7 April 2026

**RE: 164-194 WILLIAM STREET, WOOLLOOMOOLOO SSDA
RESPONSES TO REQUEST FOR INFORMATION (RFI) – TRAFFIC AND PARKING**

A State Significant Development Application (SSD-80211463) was lodged for a proposed mixed-use infill affordable housing development at 164-172 and 174-194 William Street Woolloomooloo.

Source: FJC Studio, Sheet no. 2003, Rev 2, 28.03.2026 - Basement 1.

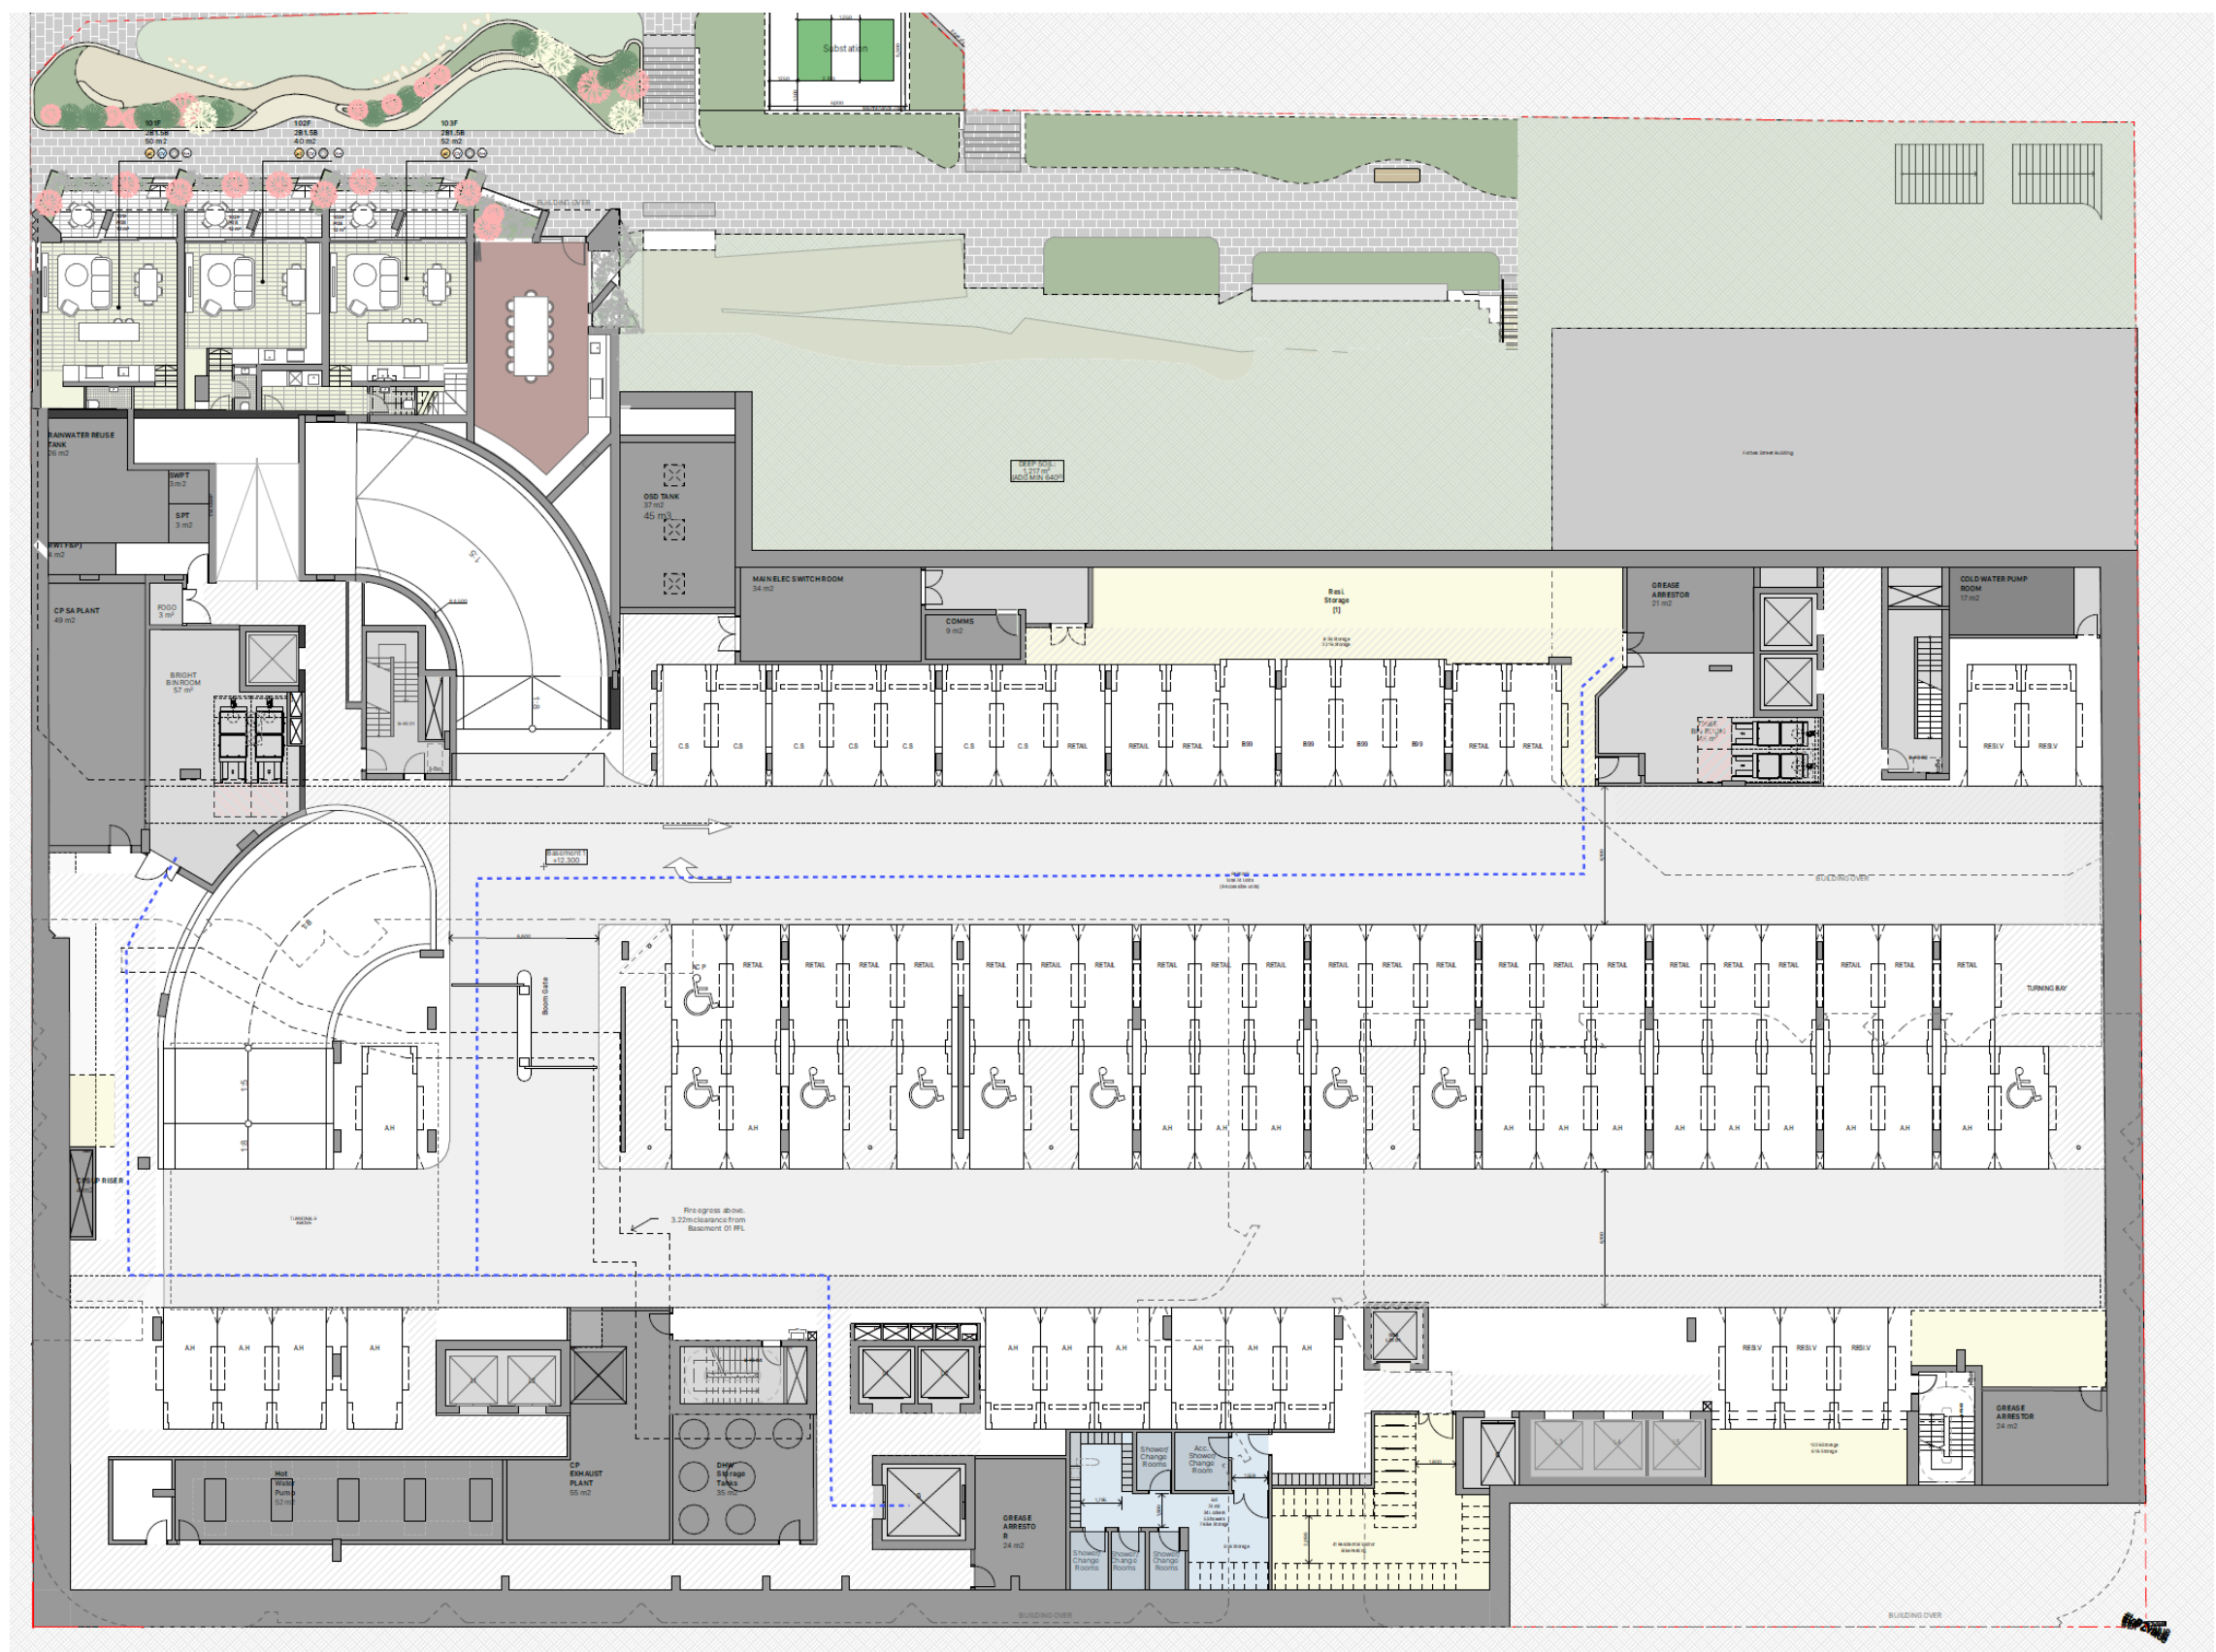
d. *Show the car parking count on basement architectural plans, including a schedule showing breakdown by allocation type and total.*

The parking schedule has been shown on the revised architectural plans for the basement levels that includes a breakdown of residential, visitors and retail car parking.
